Awel y Môr Offshore Wind Farm

Comments on Land Use Consultants' Review of LVIA and SLVIA

Deadline 2

Date: 09 November 2022

Figure: 31c
 Viewpoint 4: Moelfre Headland at sculpture
 Awel y Môr Offshore Wind Farm
© Crown copyright. All rights reserved (2021). Licence number 0100031673

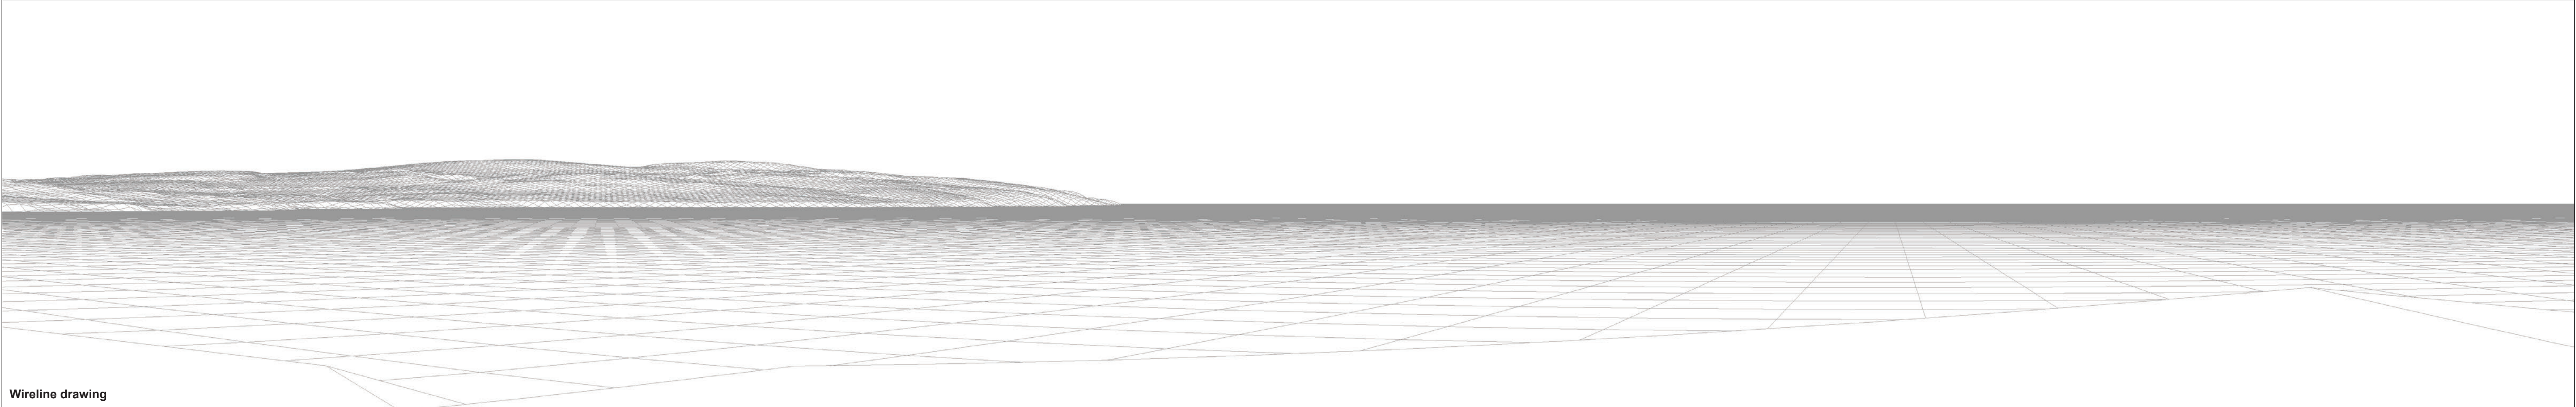
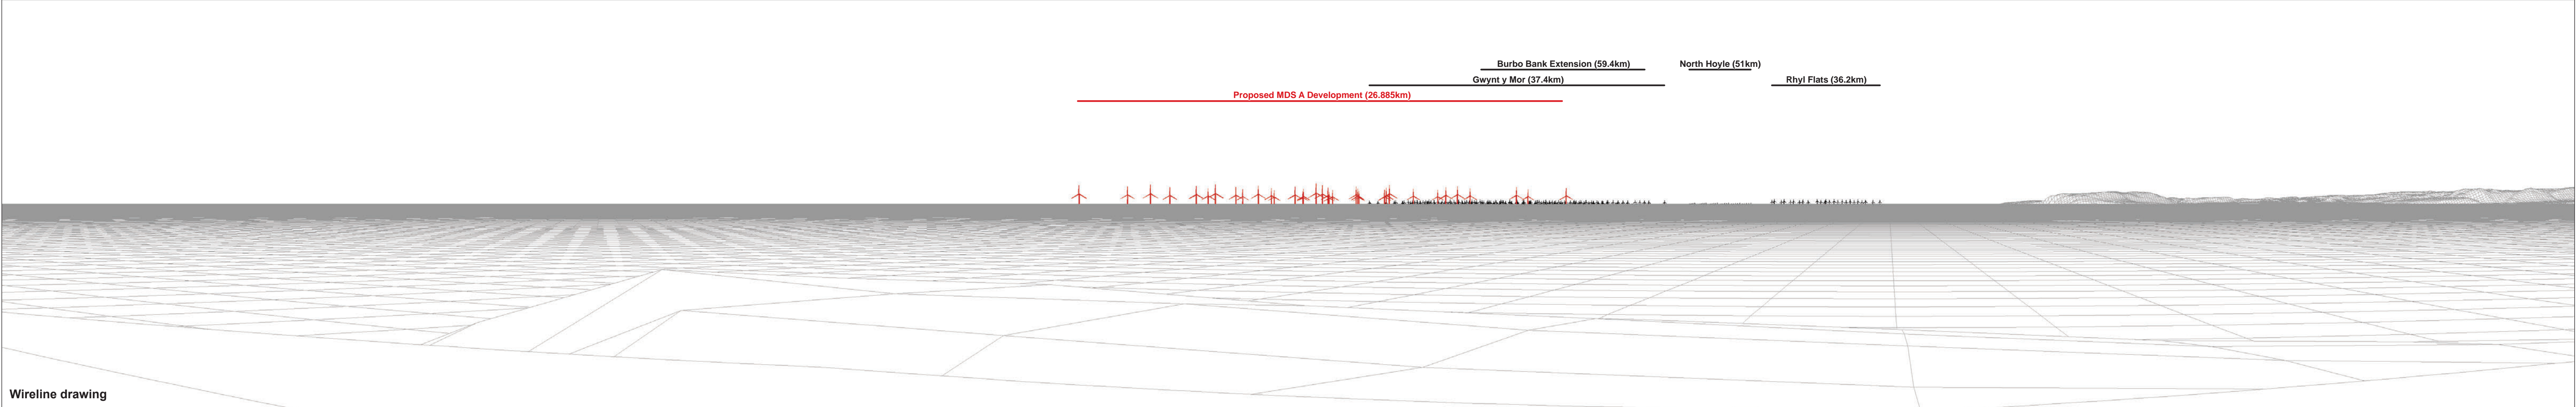
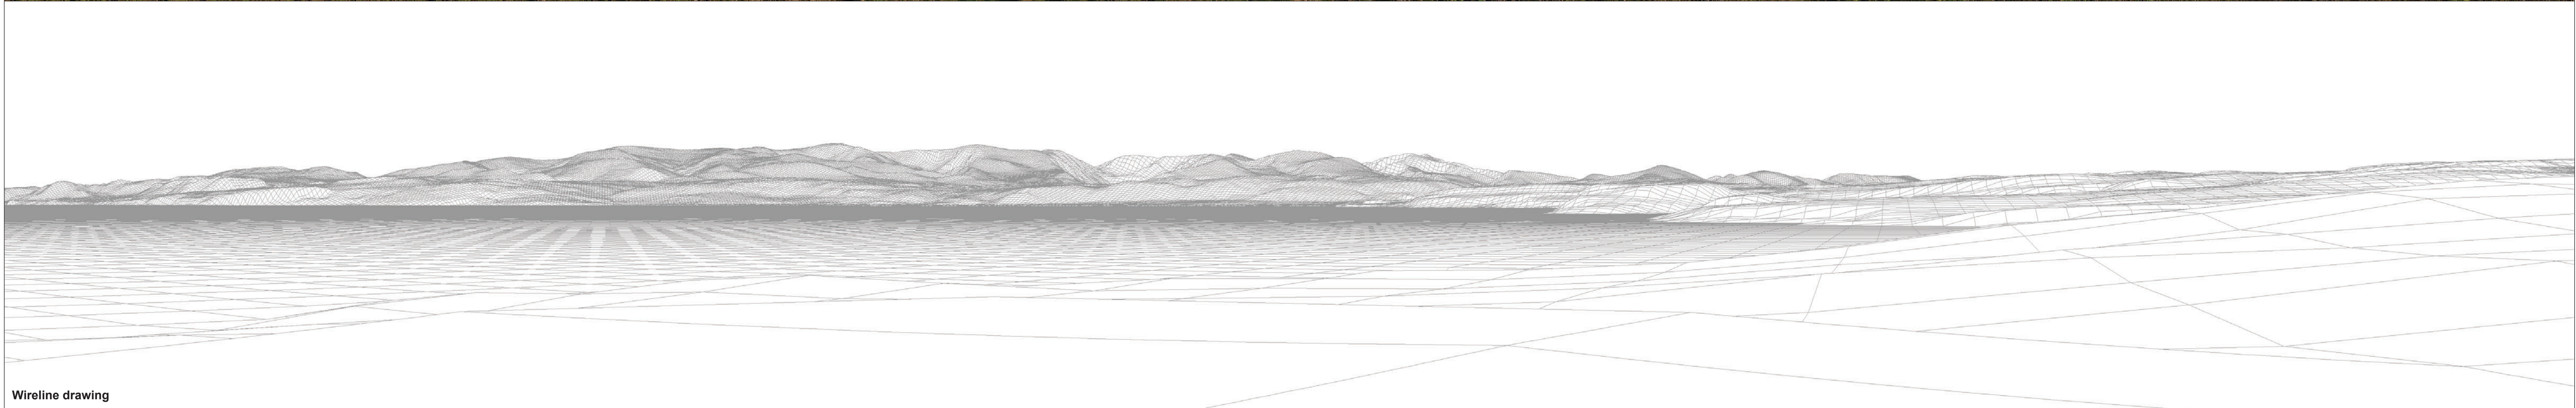
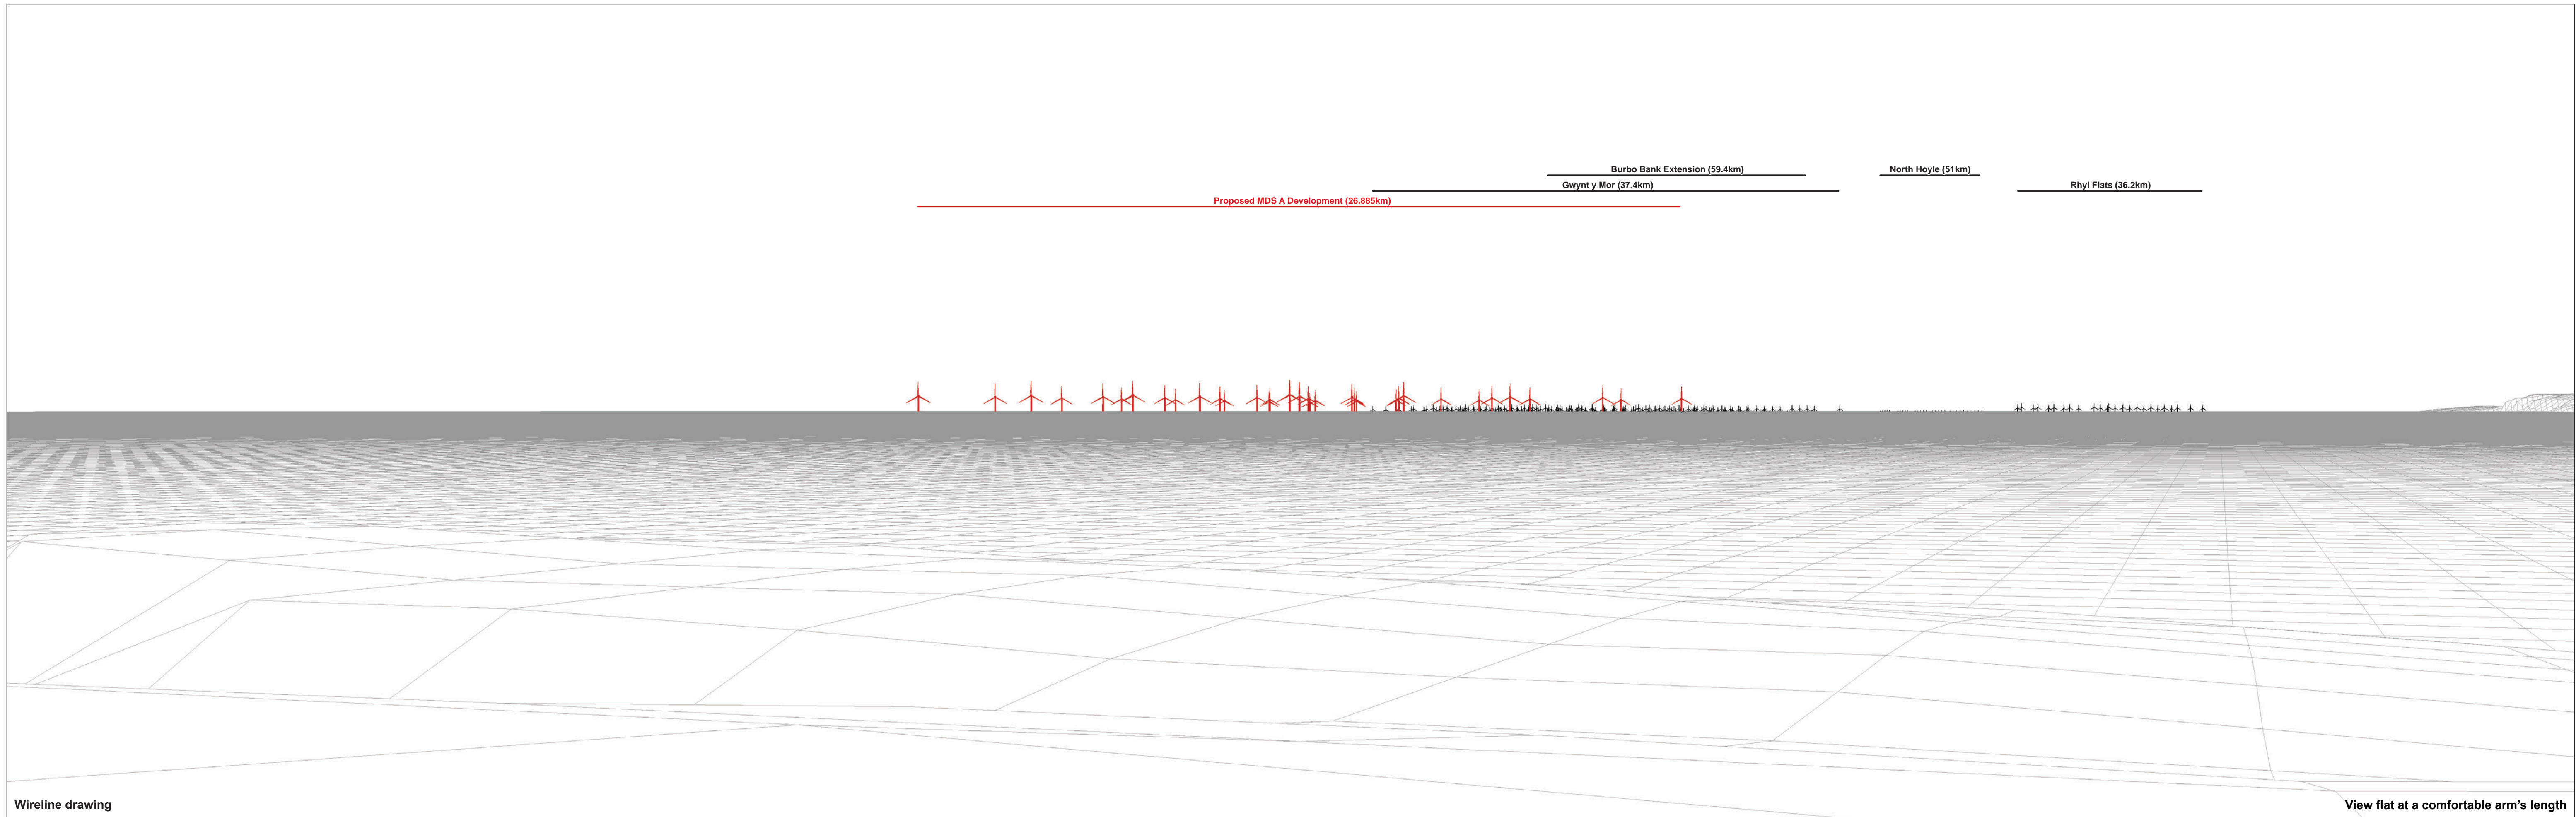
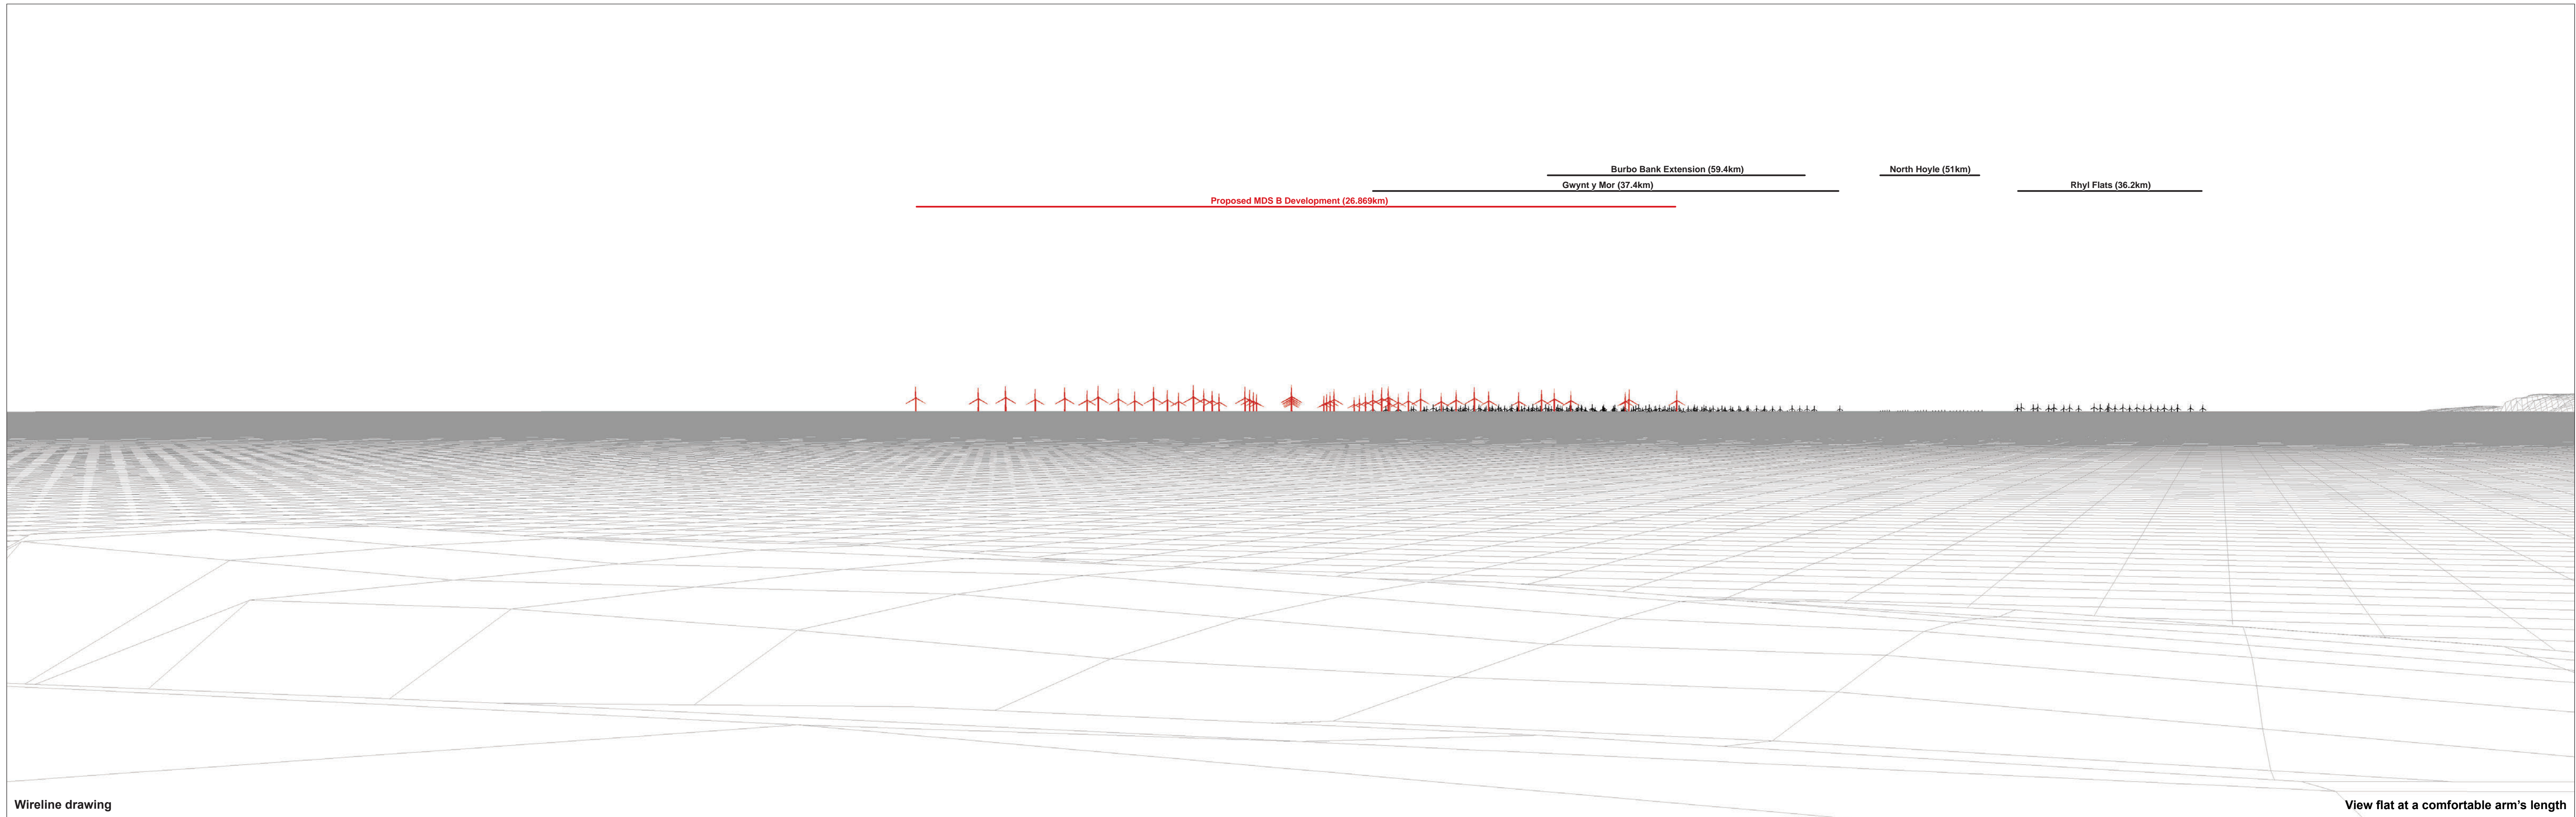
VP 4. Moelfre Headland at sculpture (daytime)	Significant	Agreed	Moderate (significant)	Agreed	Agreed	Agreement noted.
VP 5. Red Wharf Bay	Significant	Agreed	Moderate (significant)	Agreed	Agreed	Agreement noted.

Viewpoint 4. Moelfre Headland at sculpture (night-time)	Significant	Agreed	Minor (non-significant)	Agreed. At PEIR the magnitude of change for 2000 candela lights was medium-low. This has reduced to negligible for 200 candela lights.	Agreed at REP1-080-Annex B - 6.1.33	Agreement noted
Across Isle of Anglesey, with reference to:	Locally significant, but	Agreed: the SLVIA assesses significant night-time effects "in	Moderate-minor (non-significant) in the vicinity of	Agreed for the 200 candela scenario.	REP1-080-Annex B - 6.1.33	Agreement noted
